**RE: Durango Subdivision, Units 3 - 5  
Tr H, Durango Unit 1 & Tr A Durango Unit 3A  
Drainage Report Stamp Date: 3/5/15  
Unit 3 Grading Plan Stamp Date: 8/12/15 (Approved for Plat, 8/18/15)  
Unit 3A Grading Plan Stamp Date: 1/18/19  
Unit 4 Grading Plan Stamp Date: 8/12/15 (Approved for Grading, 8/18/15)  
Unit 5 Grading Plan Stamp Date: 1/18/19  
Hydrology File: C09D012**

Based on the submittal received on 1/18/19 the above-referenced Grading Plans cannot be approved until the following are corrected:

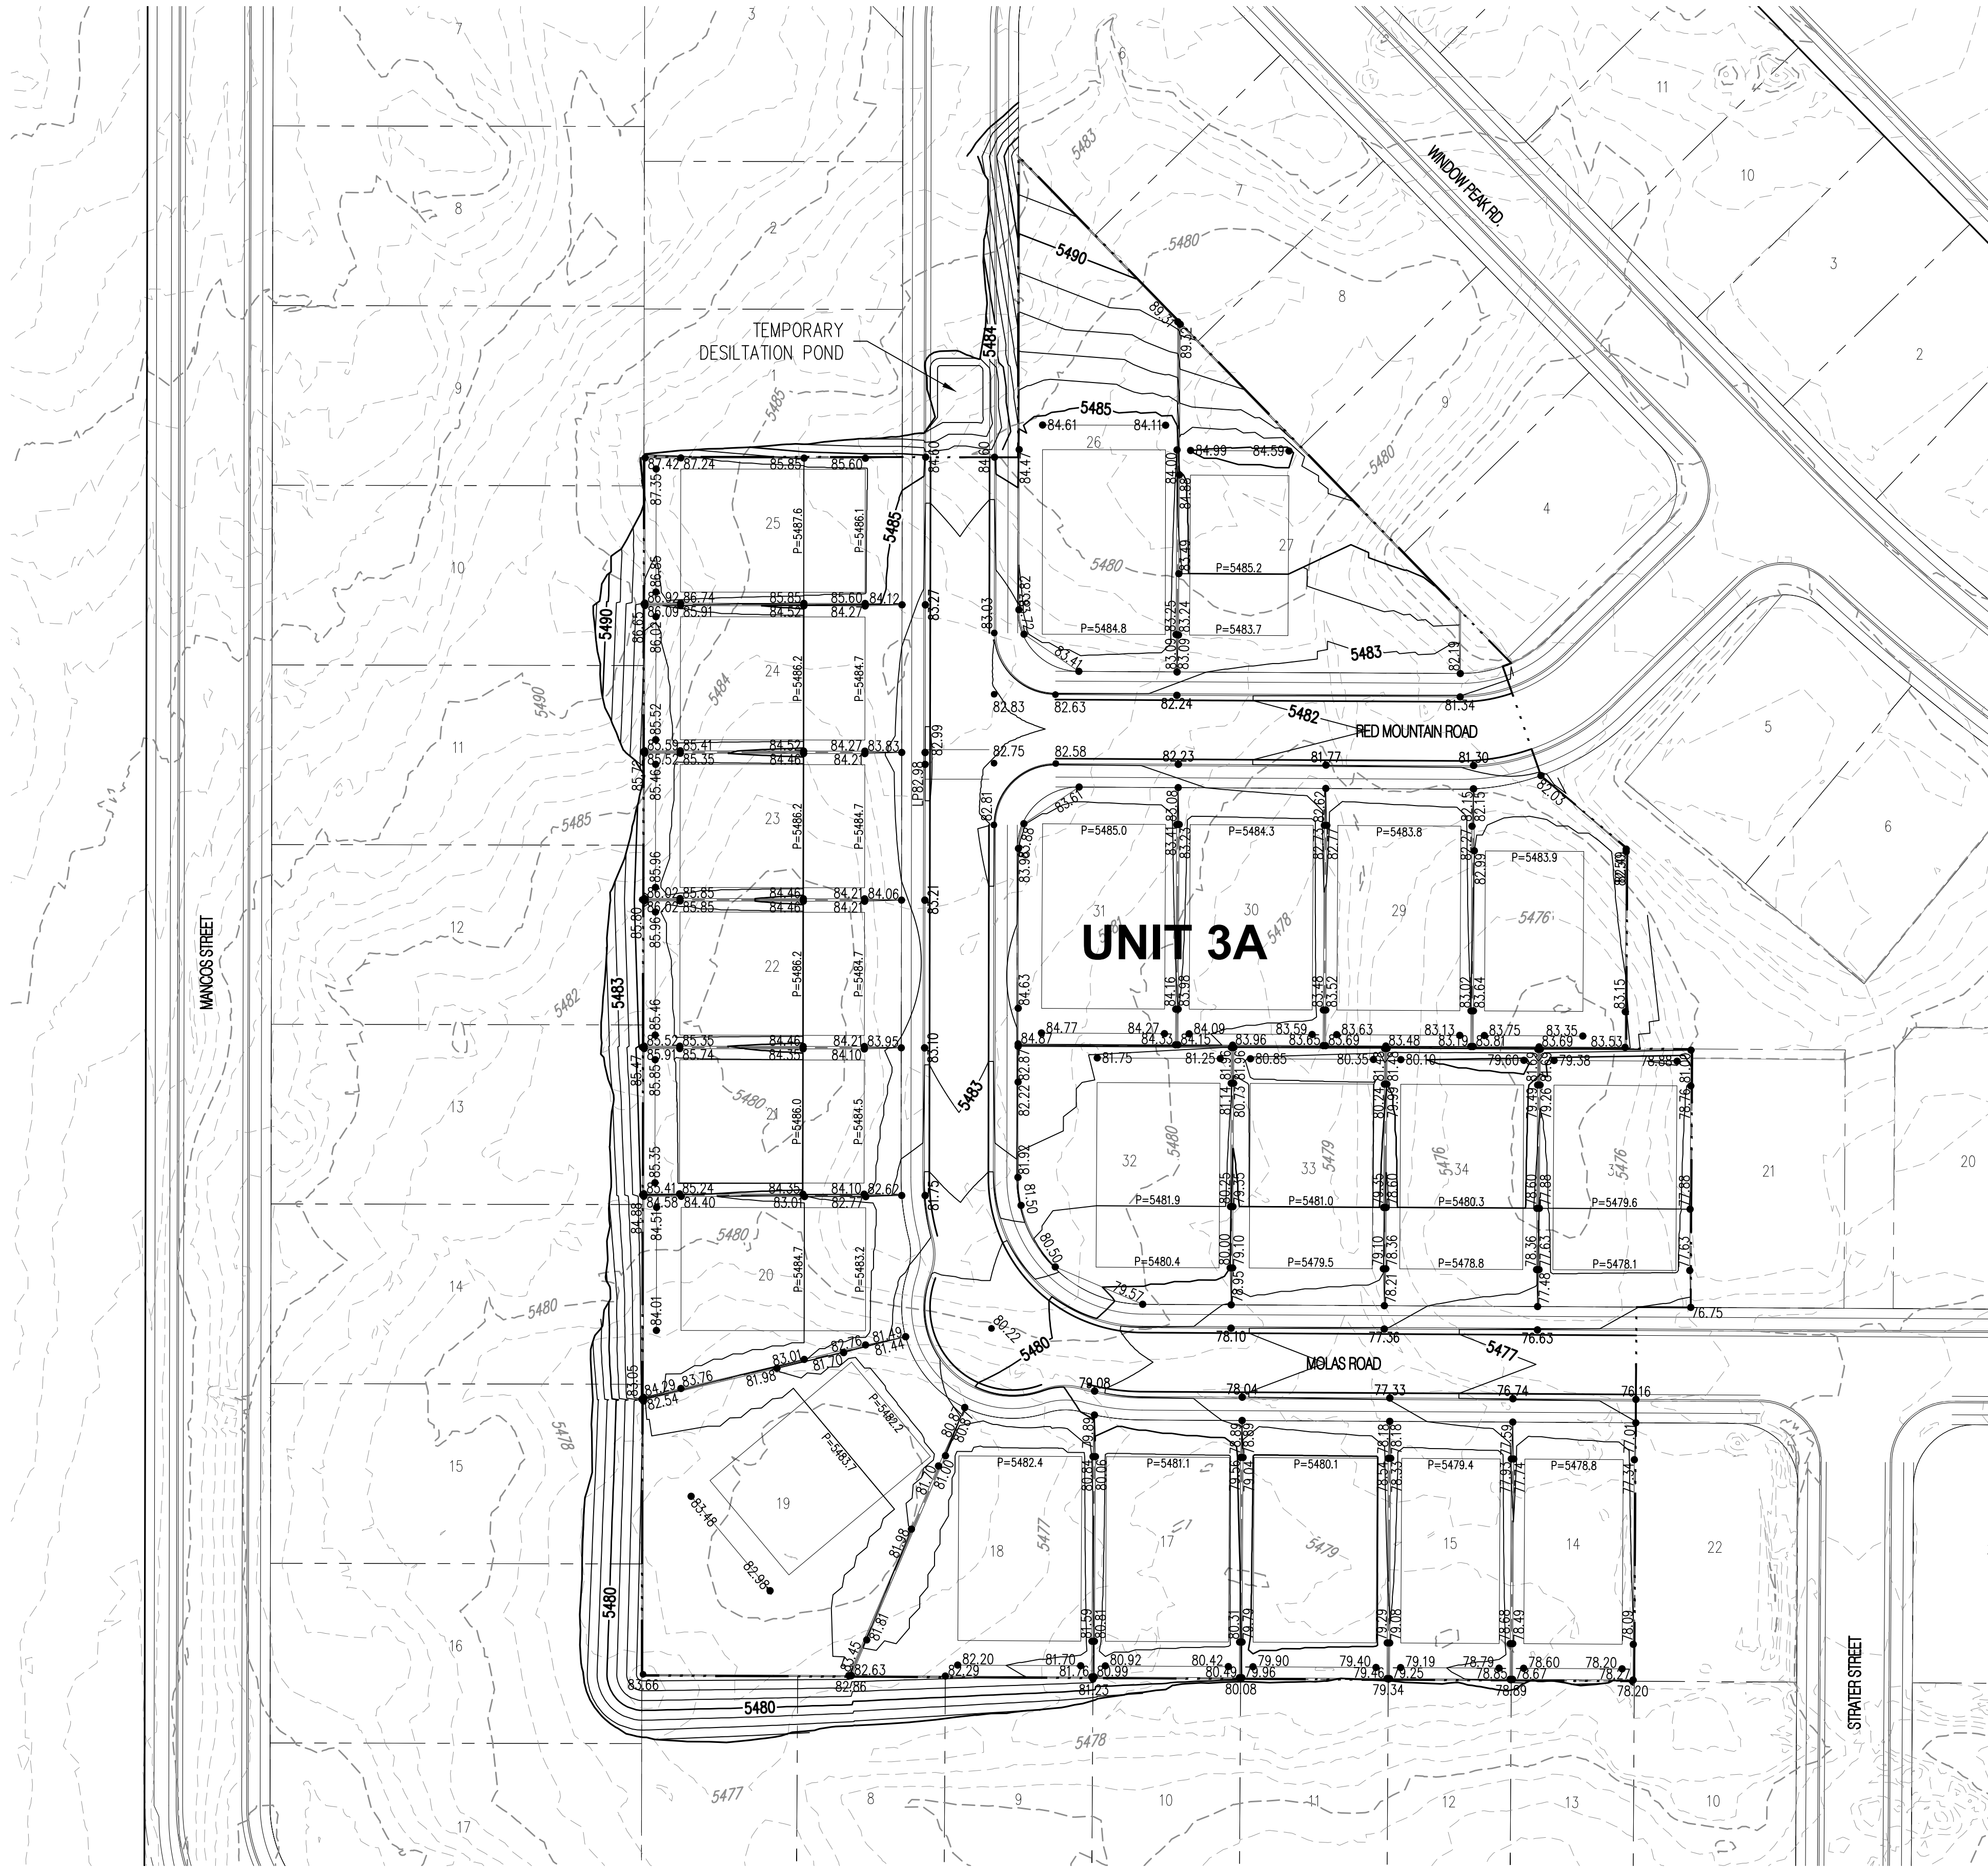
2. Show the storm drain network on the Grading Plan (vicinity of Unit 3A); delineate which portions have been constructed (any portion of the storm drain that hasn't been constructed and accepted will need to be added to the infrastructure list).

3. Existing and proposed contour labels are missing for Unit 3A. In Unit 5, please increase the density of existing and proposed contours along the external boundaries. The slope indicators appear to be reversed along the 4:1 tie-in slope.

4. Provide a temporary pond on Coal Bank St where Unit 4 ties in (Unit 3A). Prior to Unit 3 ROFG, a temporary drainage easement on the temporary ponds will be needed, unless the upstream road portions have been built.

5. How will flows be directed from the west side of Coal Bank St to Red Mountain Rd (Unit 3A)? It appears that a valley gutter is needed here.
6. Identify internal retaining walls to be constructed by the developer (prior to Pad Cert) and those to be deferred to homebuilder. Any wall retaining 2 feet or more will need to be
